Application for a non-material amendment following a grant of planning permission.

Unit:		House number:		House suffix:	
House name:					
Address 1:	BARNHAM COMMUNITY HALL				
Address 2:	YAPTON ROAD				
Address 3:					
Town:	BARNHAM				
County:					
Postcode (optional):	PO22 0BD				
Description of location or a grid reference. (must be completed if postcode is not known):					
Easting:		Northing:			
Description:

REPLACEMENT VILLAGE HALL WITH THE ERECTION OF A TERRACE OF
4 NO 2 BED HOUSES AND 4 NO 3 BED HOUSES ON FORMER
VILLAGE HALL SITE

BN / 3 / 09

Drawing Title:
2-Bed Terrace Cottages

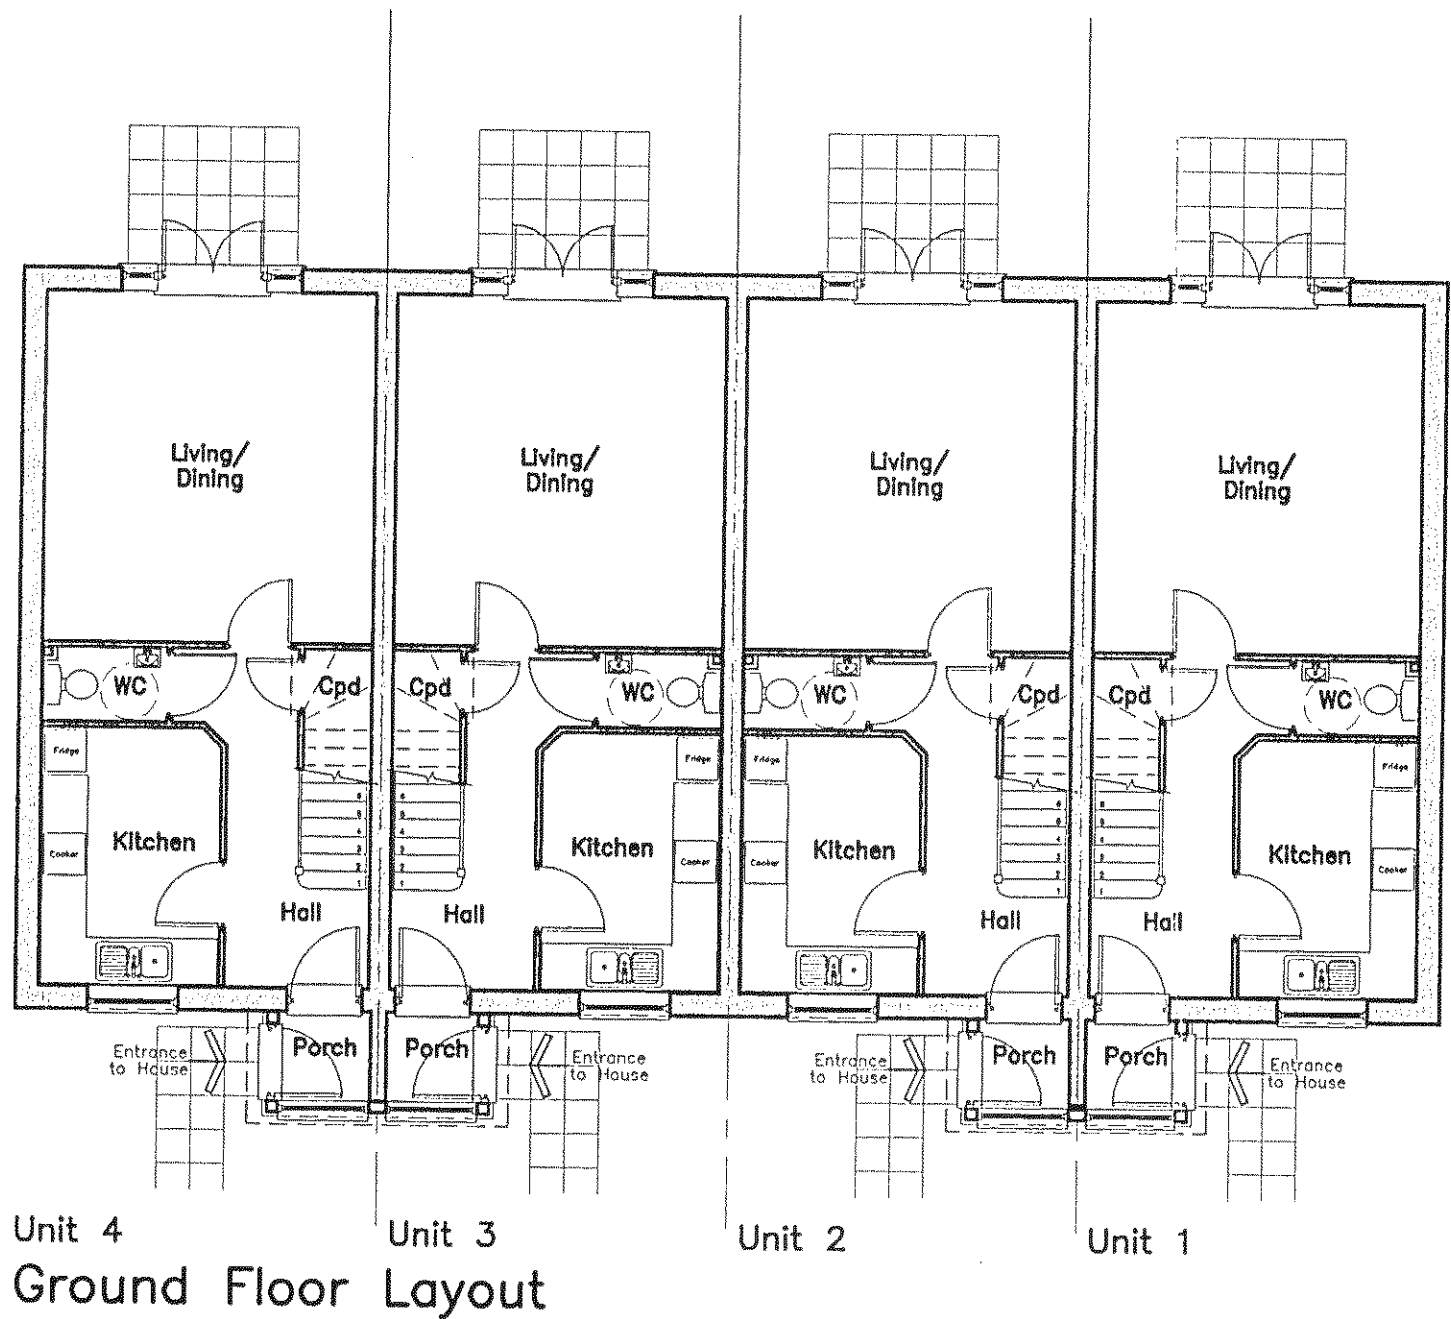
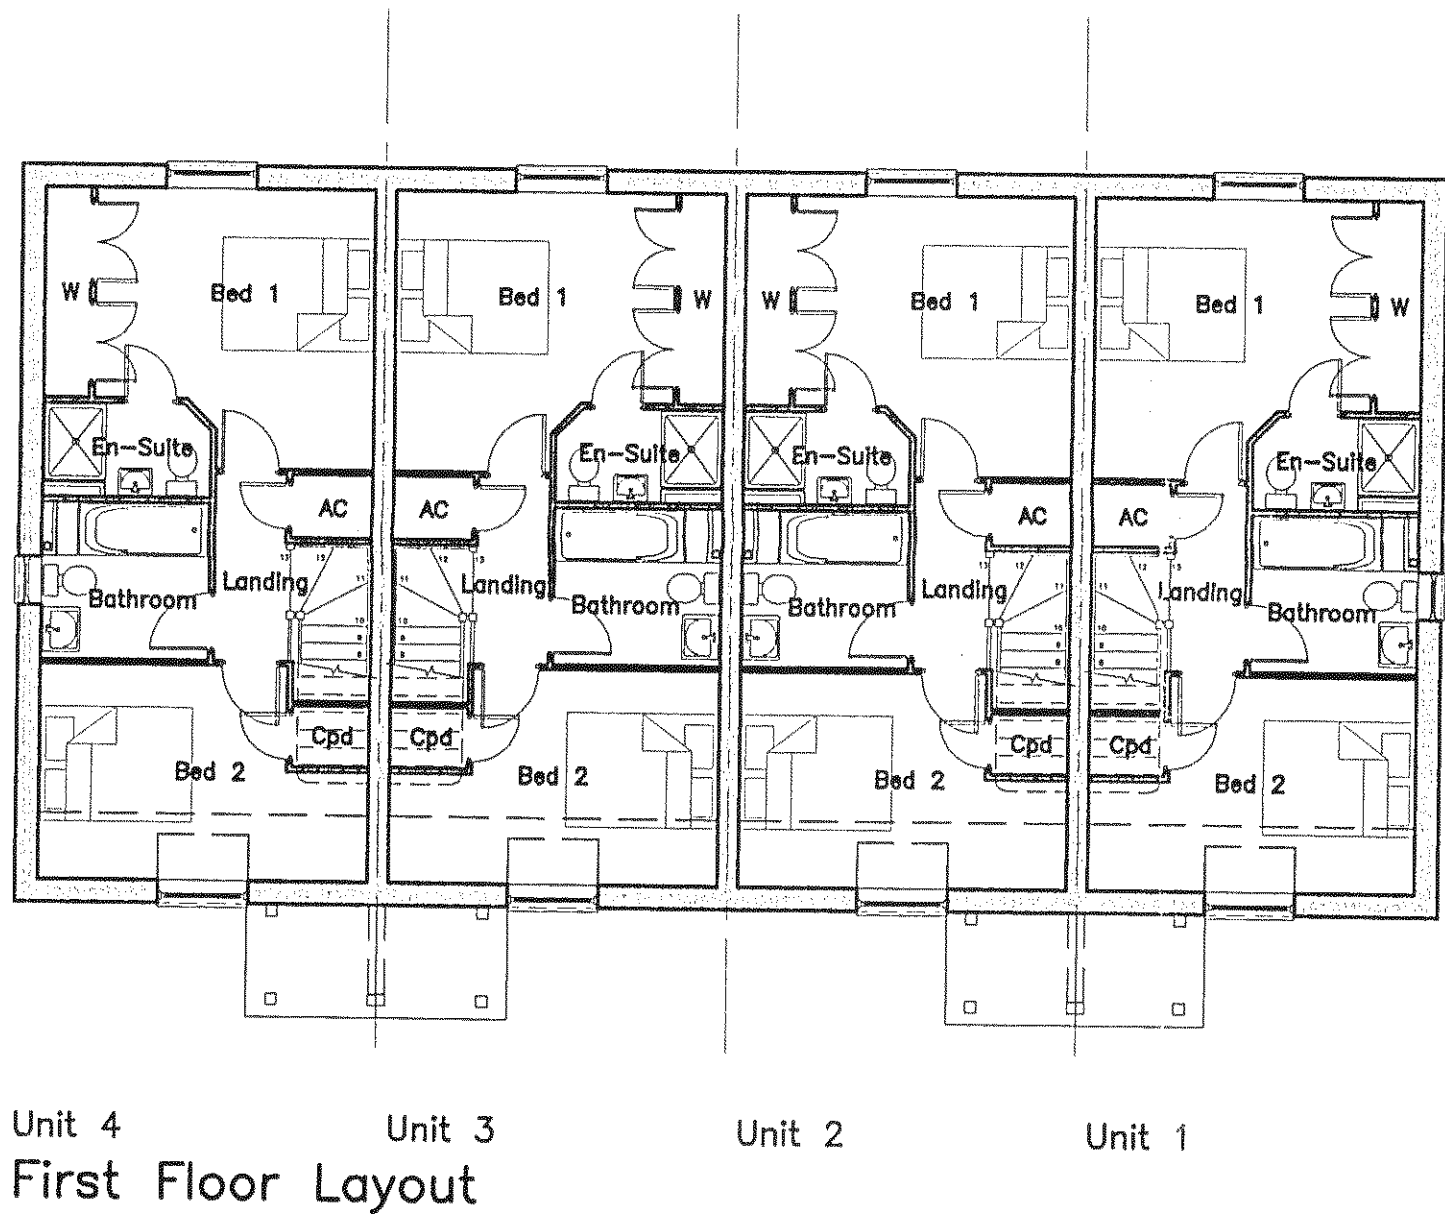
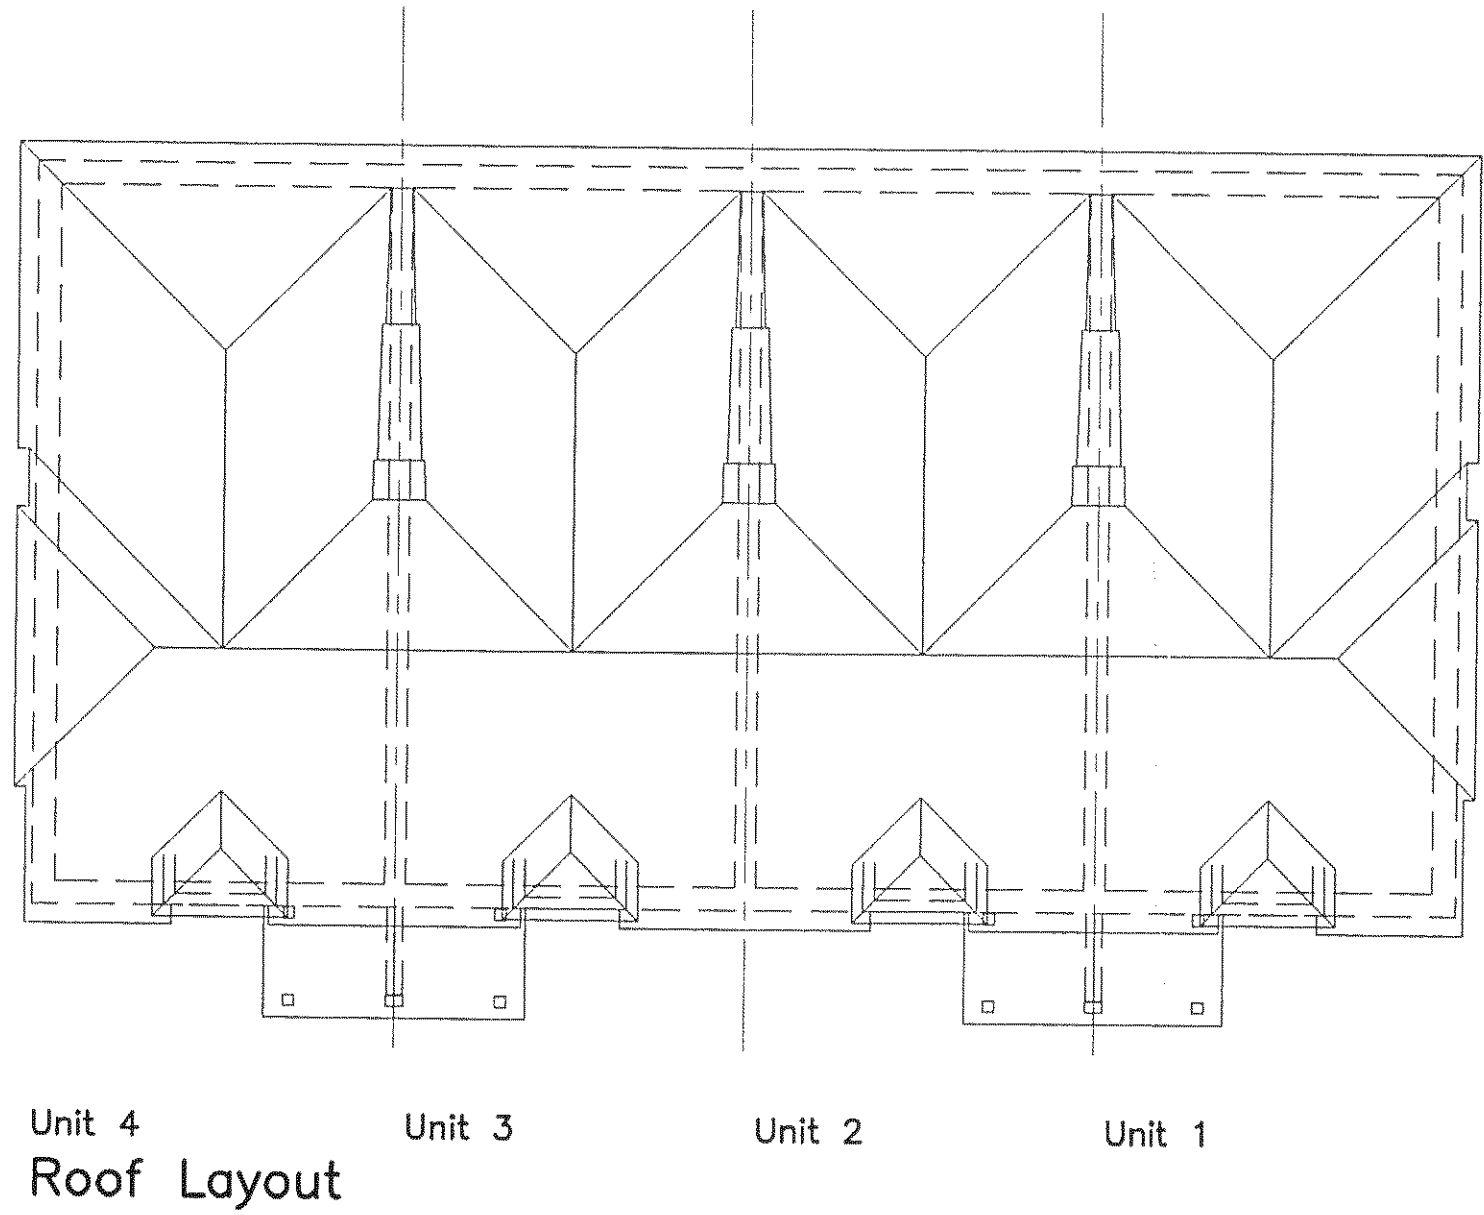
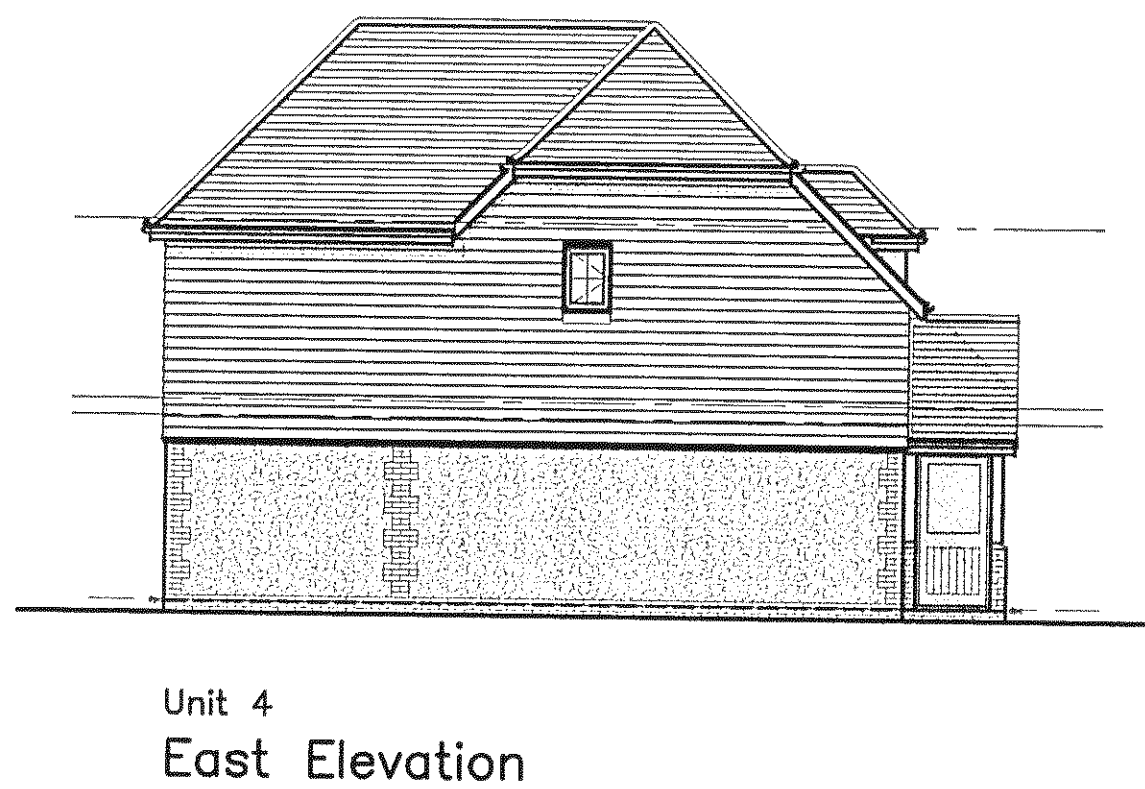
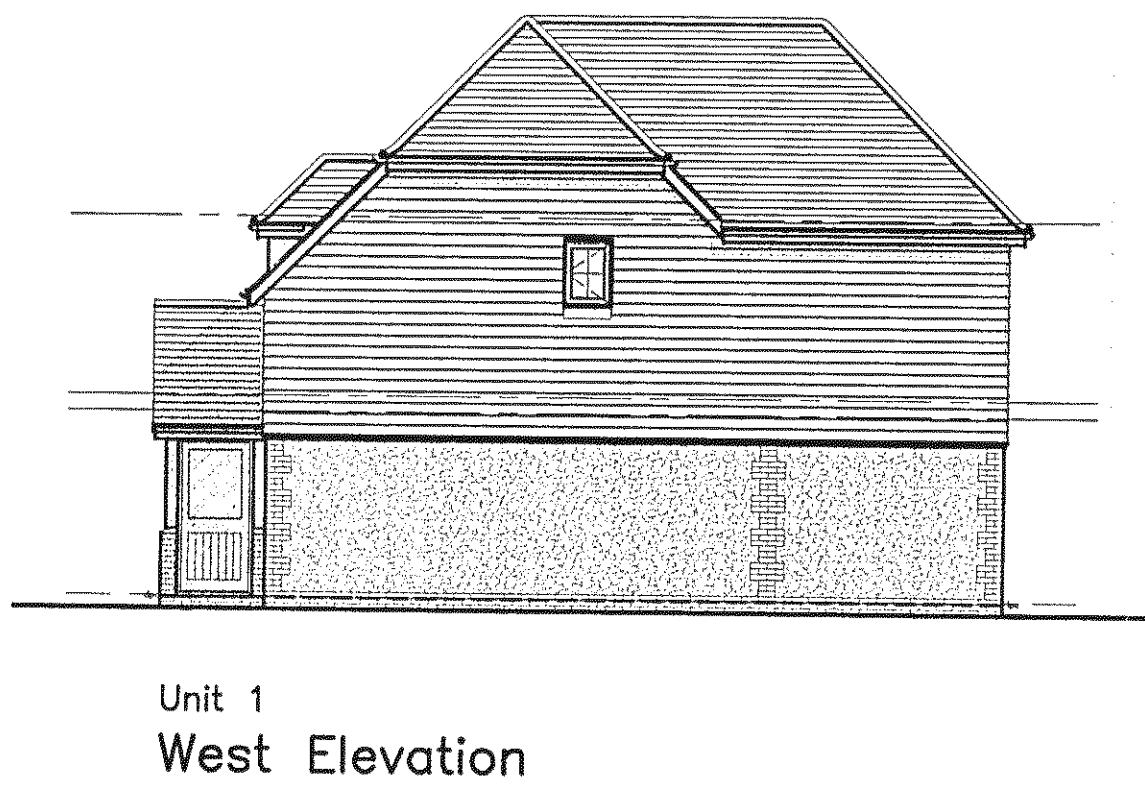
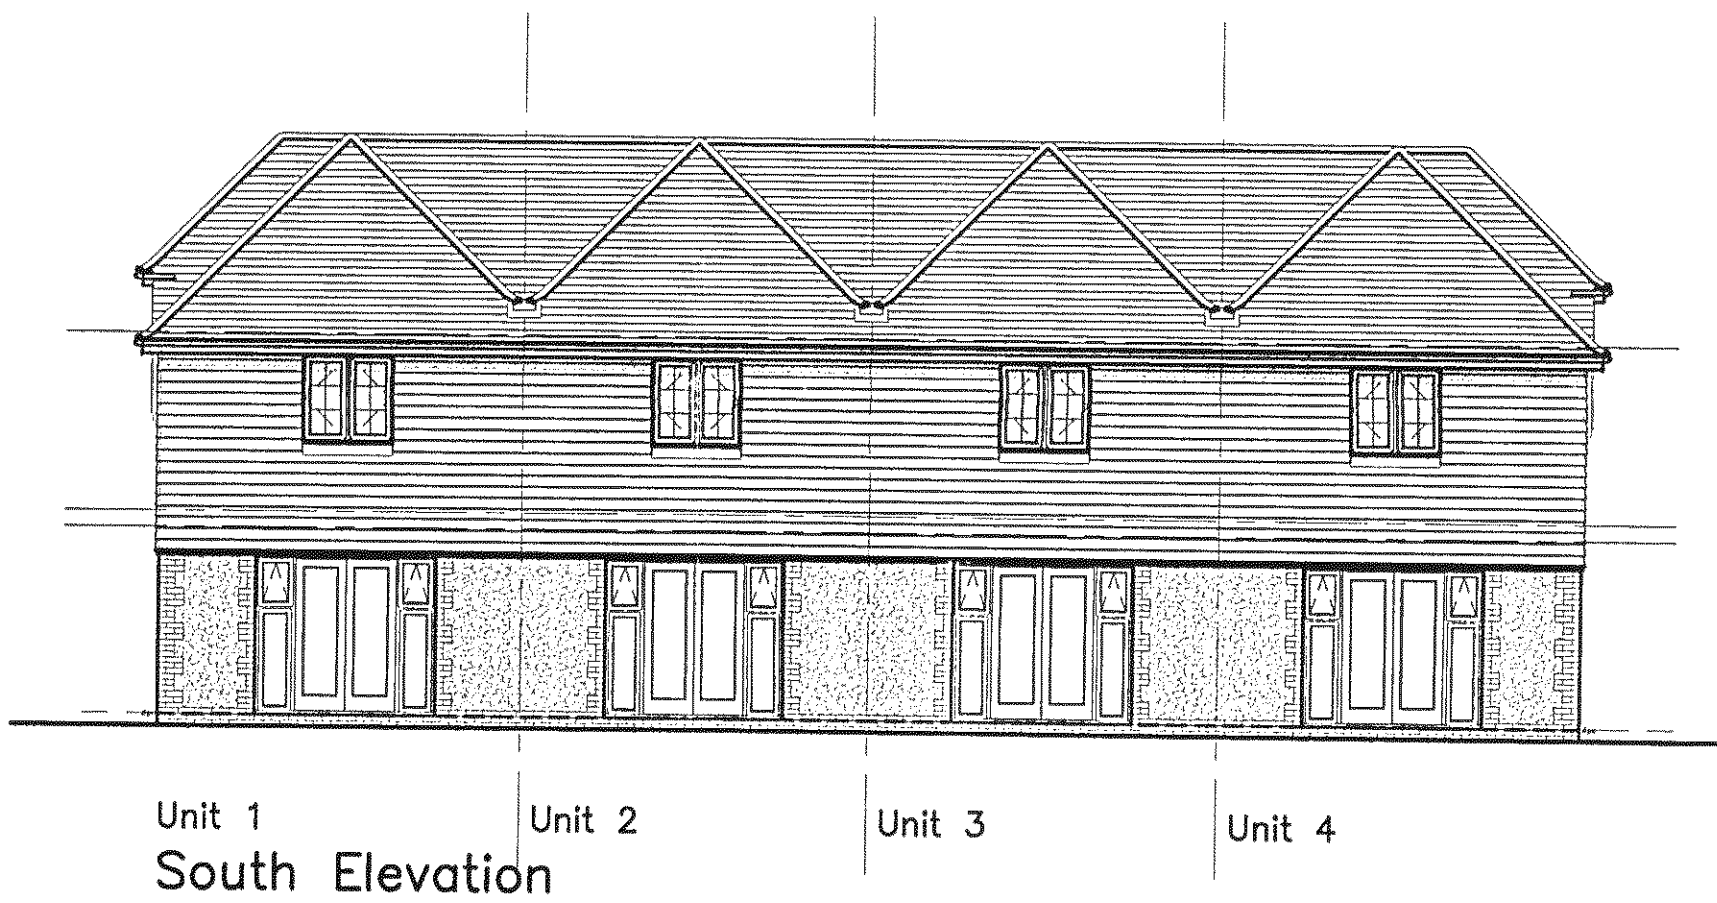
MINOR CHANGES TO PRECISE LOCATION OF THE FIRST FLOOR WINDOWS
IN BOTH EAST AND WEST END / SIDE ELEVATION TO BOTH TERRACES
(PLOTS 1 AND 4 ; 5 AND 8) - HOUSING ELEMENT.

1/ TO IMPROVE THE INTERNAL ARRANGEMENTS OF THE PROPOSED
LIVING ACCOMMODATION, AND
2/ TO REGULARISE ON A CLEARER MORE ACCURATE PLAN THE
SITE LAYOUT ARRANGEMENTS.
